20200376.3/0608A/R2/AW

6/08/2021

**Woolworths Customer Fulfillment Centre (CFC), 74 Edinburgh Road, Marrickville - Response to Submissions**

Figure 16 – Required Acoustic Barriers for Level 1 Carpark

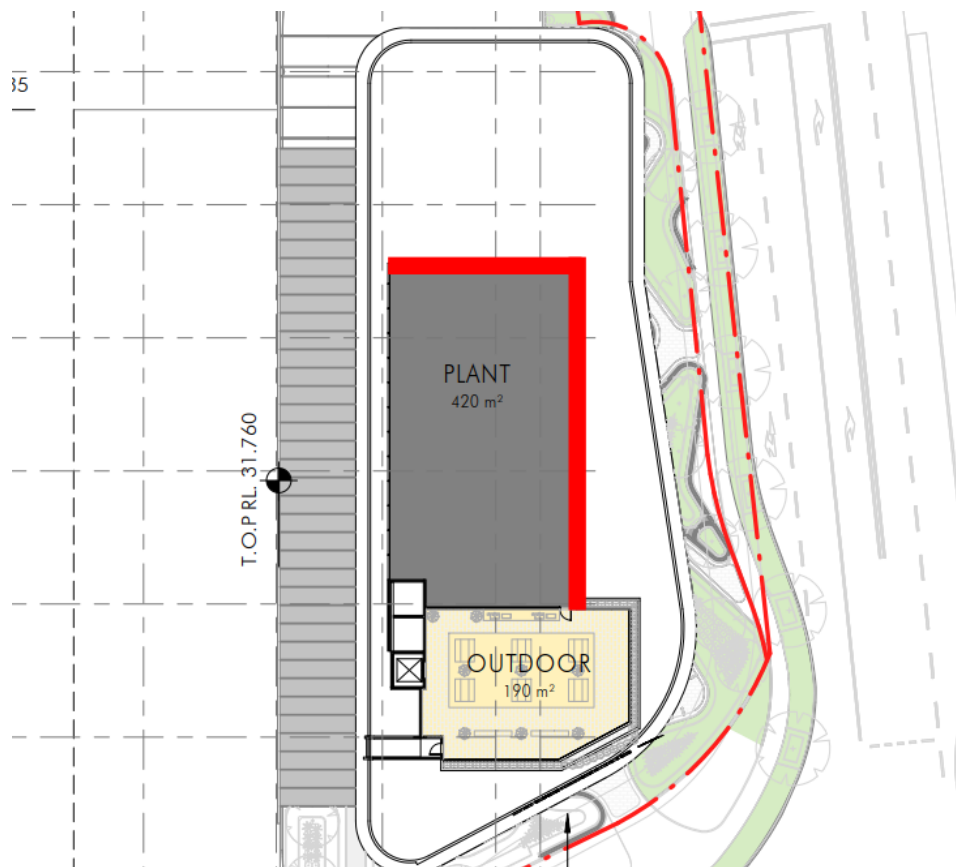
<p>Concerned there is no wall or screening of the car park onto Edinburgh Road.</p>	<p>The updated acoustic report has recommended screening to carpark areas located along Edinburgh Road. Refer Section 7.6.</p>
<p>Concerned the 24-hour operation of the premises will give rise to vehicles going in and out of the car park at night, the slamming of car doors, shining lights directly into residential properties, noise from conversations and car radios.</p>	<p>Noise from the use of the carpark has been assessed and found to meet the requirements of the NPI. The assessment has considered both vehicles entering the development, manoeuvring to parking spaces and instantaneous peak noise events, such as vehicle doors closing or engines starting.</p>
<p>Main concern is the 24-hour operation of the warehouse and the subsequent disturbance to sleep.</p>	<p>The NPI provides an assessment criteria for sleep disturbance, which is based on peak (<math>L_{max}</math>) noise levels relative to the prevailing background noise level during the night time period. Peak noise levels from vehicle movements on site (both passenger and trucks) have been predicted, and are below the relevant emergence levels detailed in the policy.</p>
